Rezoning Transportation Analysis

Petition Number: Insert Zoning Petition #2022-024

Date	Description
07-26-22	First Review (TM)

SHEET NUMBER  
**RZ-01**

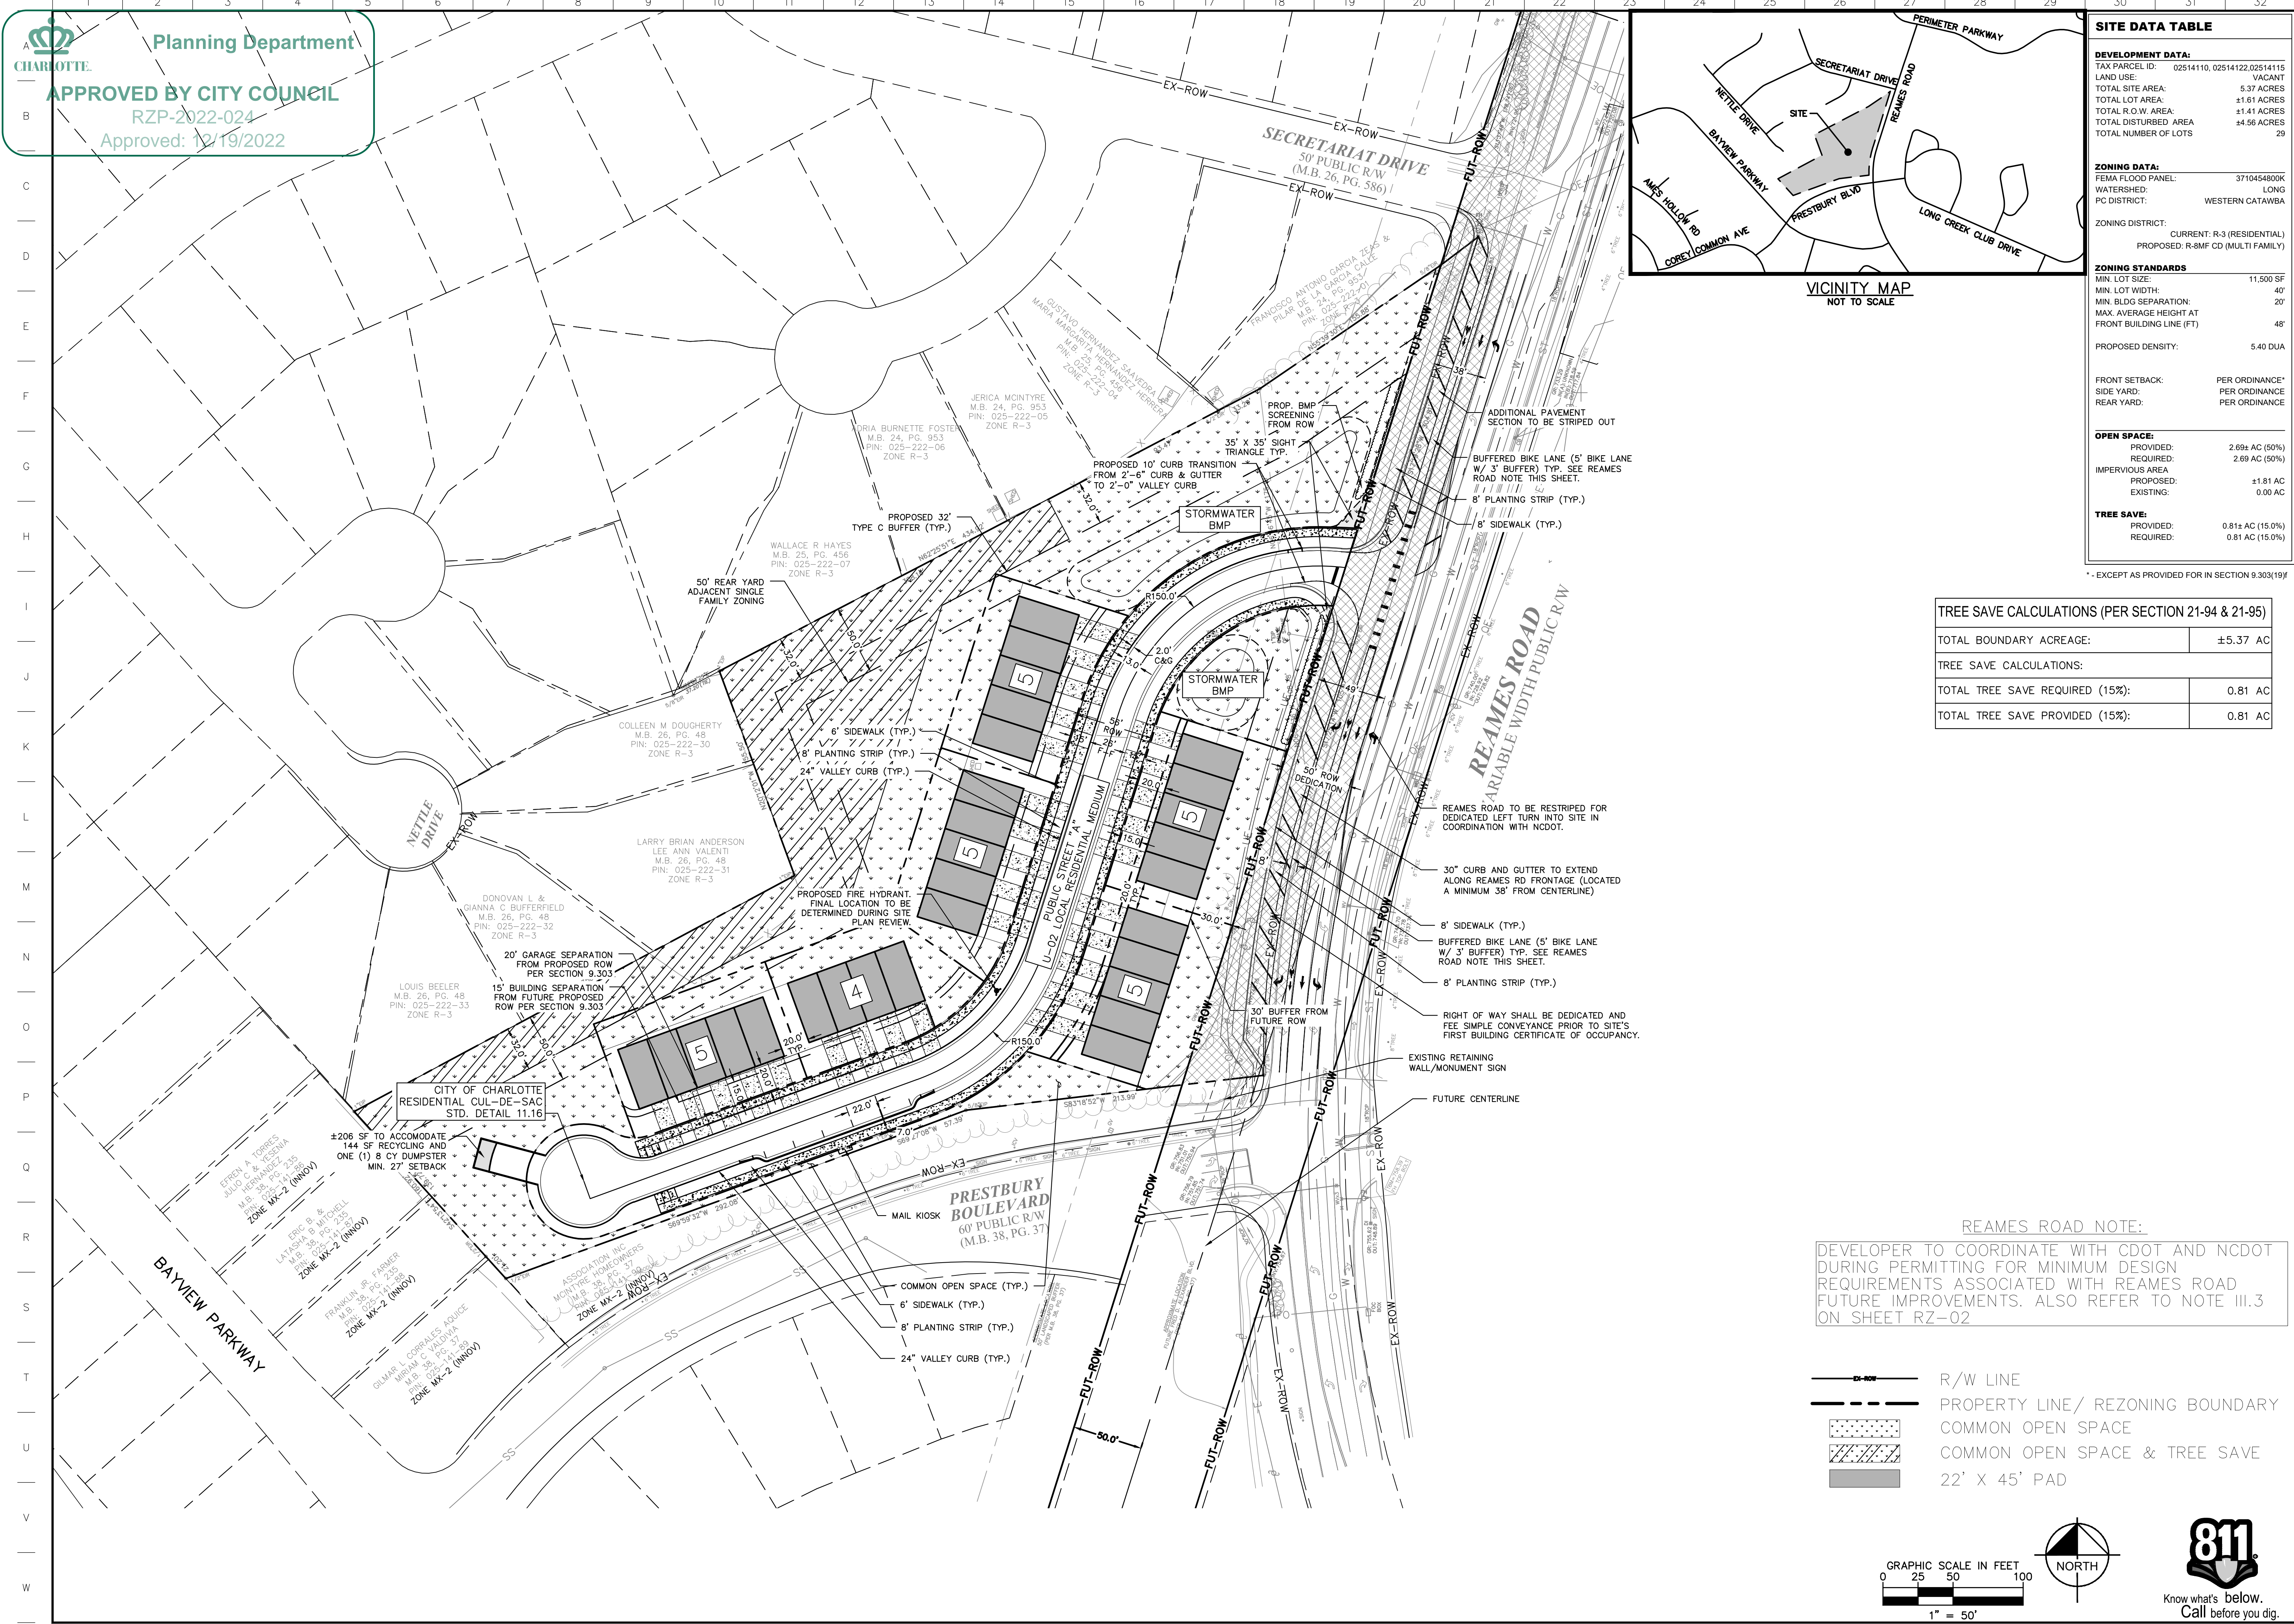
1. **Curblines:** The proposed zoning district has a setback measured from back of the existing or proposed future curblines.
 - a. **Reames Road:** The future location of curb and gutter is located 38-feet from the centerline.

Label and dimension the curb and gutter from the centerline for each road on the site plan.

3. Revise site plan and conditional note(s) to commit to dedicate 50-feet of right-of-way from the road centerline. The site plan shall label and dimension the right-of-way from the Reames Road centerline.

4. Site plan and conditional note(s) revisions are needed to commit to restriping Reames road for a left-turn lane into the site per NCDOT coordination. Label and dimension left-turn lane on site plan and add conditional note describing all turn lane design requirements.

5. Site plan revisions are needed to dimension to location of the future right-of-way to be dedicated for the proposed CTP alignment.
6. **CDOT REQUEST:** CDOT requests the internal street be constructed as a private street built to public street standards.

7. Site plan and conditional note(s) revisions are needed to commit to construct bicycle facilities by locating the curb and gutter 38' from the center line to meet the Charlotte BIKES Council-Adopted Policy. The right turn lane for Prestbury Road is not accounted for in the 38-foot measurement, so additional space will be required for the existing right turn lane. Provide buffered bike lane along the frontage of the site between the through and right turn lane.
